The Member-Secretary,
Chennai Metropolitan
Development Authority,
1, Gandhi Irwin Road,
Egmore, Chennai-600 008.

Letter No. A3/29960/08

Sub: CMDA - Planning Permission - Construction
of BF+GF+IF

& consulting office
Residential/Commercial Building at plot No. 387A,
Panner Nagar, in S.No. 216/2 of Mazappan
village

PLAN SHOWING THE PROPOSED BUILDING
 PLOT NO - 387 A, IN S. NO-216 / 2 (AS PER PATTA),
 PANNER NAGAR, MOGAPAIR VILLAGE,
 AMBATTUR TALUK
 AMBATTUR MUNICIPALITY.

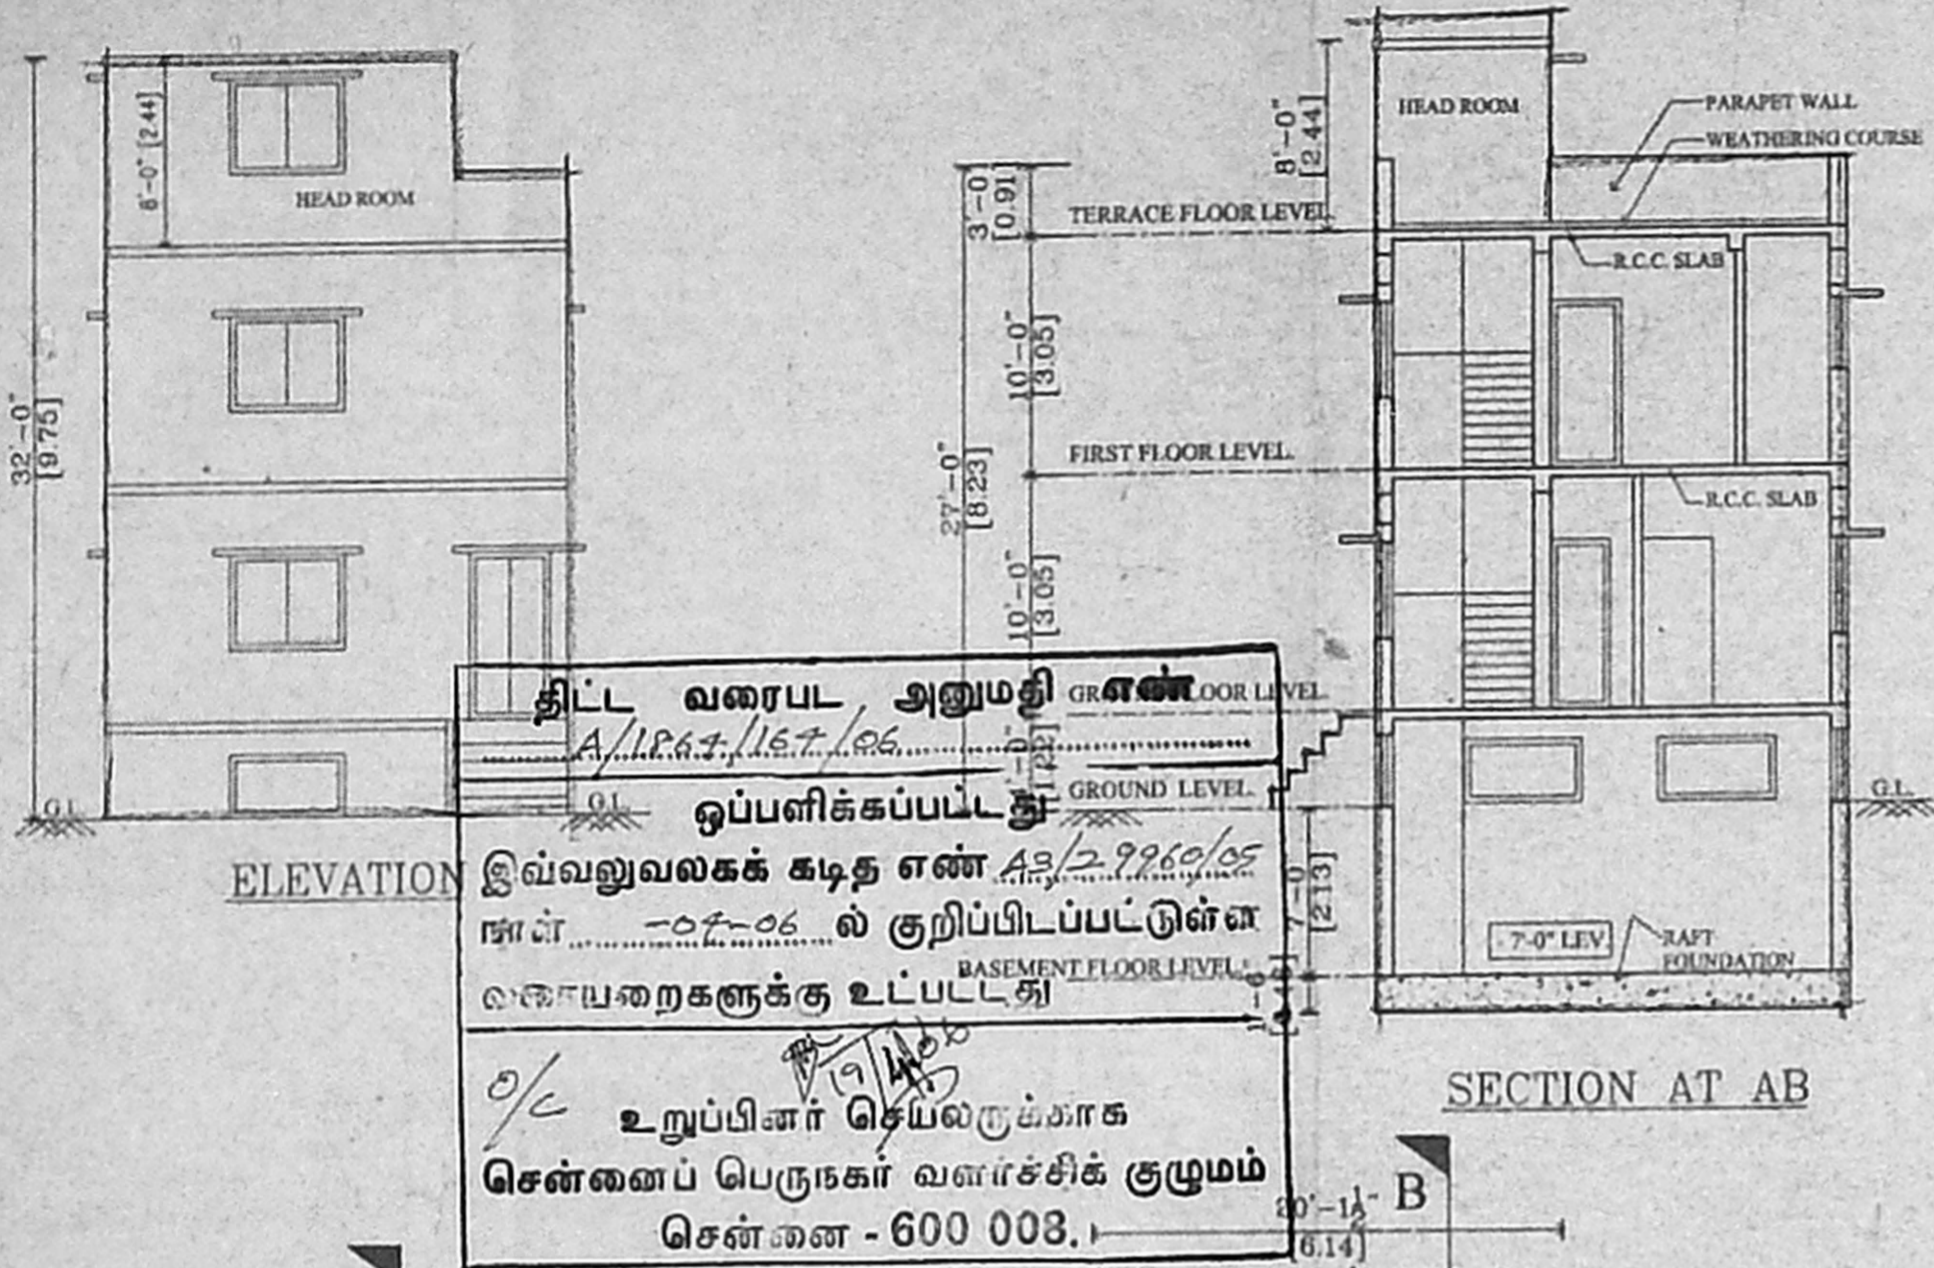
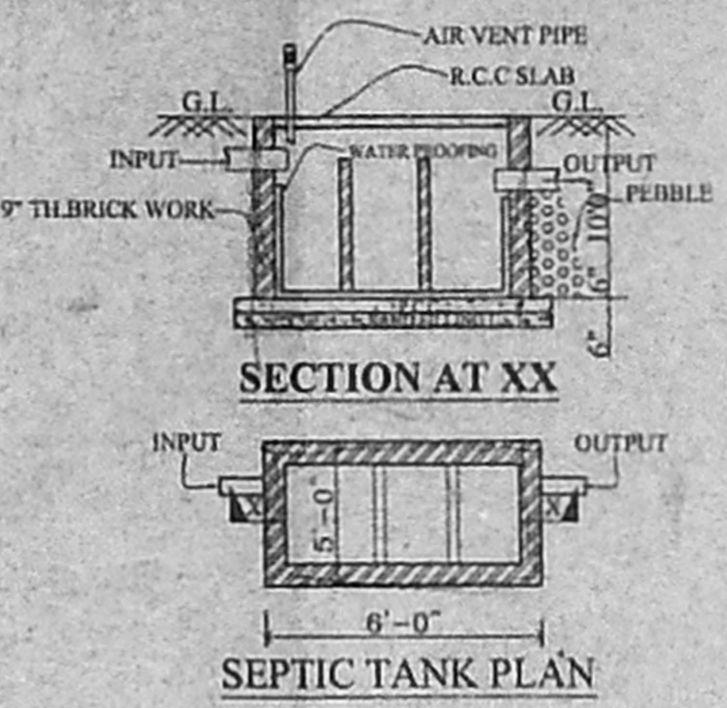
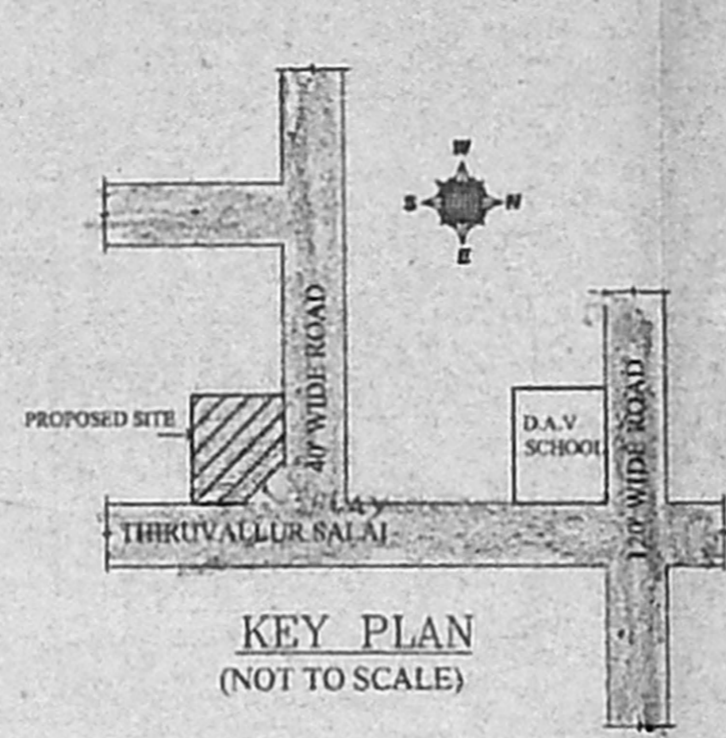
*5 copies of revised plan rectifying the defects
as below*

- 1) *crossed point in the northern side to be indicated.*
- 2) *correct Survey no. to be indicated
as per patta*
